From: [Cathy Pye](#)
To: [A47 Blofield to North Burlingham](#)
Cc: [Chris Gates](#)
Subject: A47 Blofield - North Burlingham
Date: 15 August 2021 22:32:06

Re A47 dualling Blofield - North Burlingham

Re:- A47 dualling Blofield – North Burlingham

Figure 2-7: Route of Burlingham FP3

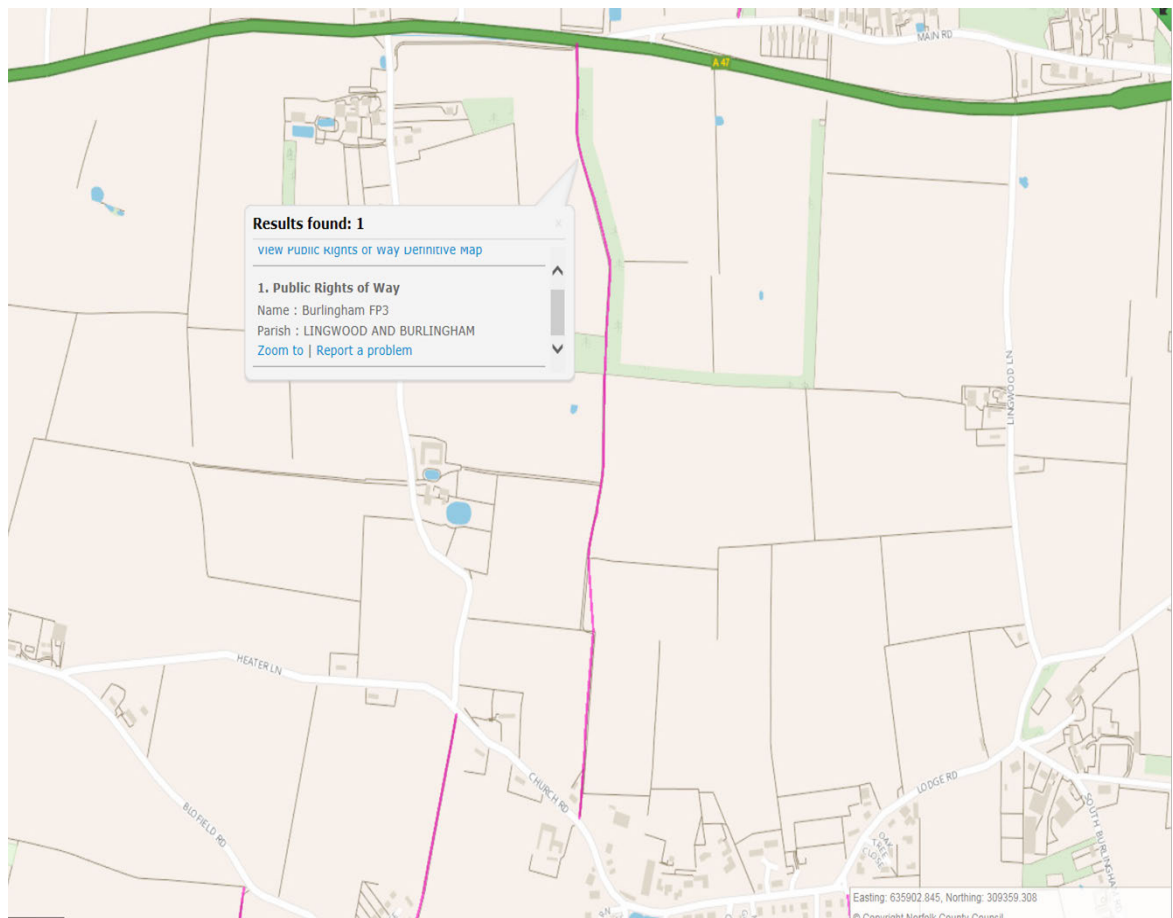
1. Concerning the footpath on the proposed eastern overbridge at the B1140 junction, Highways England has said this was incorporated, 'after consultation with Lingwood and Burlingham Parish Council'. This is true, but it was never suggested by the Council that this footpath should be built instead of a WCHR underpass at FP3!!!

As far as the parish is concerned, there is no alternative route between Lingwood and North Burlingham for walkers, cyclists and horse riders except across the A47 at the point of FP3 (or close).

I have a mobility scooter which I use occasionally but the battery range is only around 6 miles. I would be able to access the woods easily on my scooter if there was a safe crossing over the A47 at the point of FP3, but the extra distance over the proposed overbridge at the B1140 would make the journey impossible for me. (2 miles to/from the A47, plus a 2 mile detour back and forth across the overbridge, equals approximately 4 miles. That would leave me an absolute maximum of 2 miles exploration in the woods.) Also, my scooter might not be able cope with the gradient on the proposed overbridge. And I would flatly refuse to travel alongside the beet lorries!!!
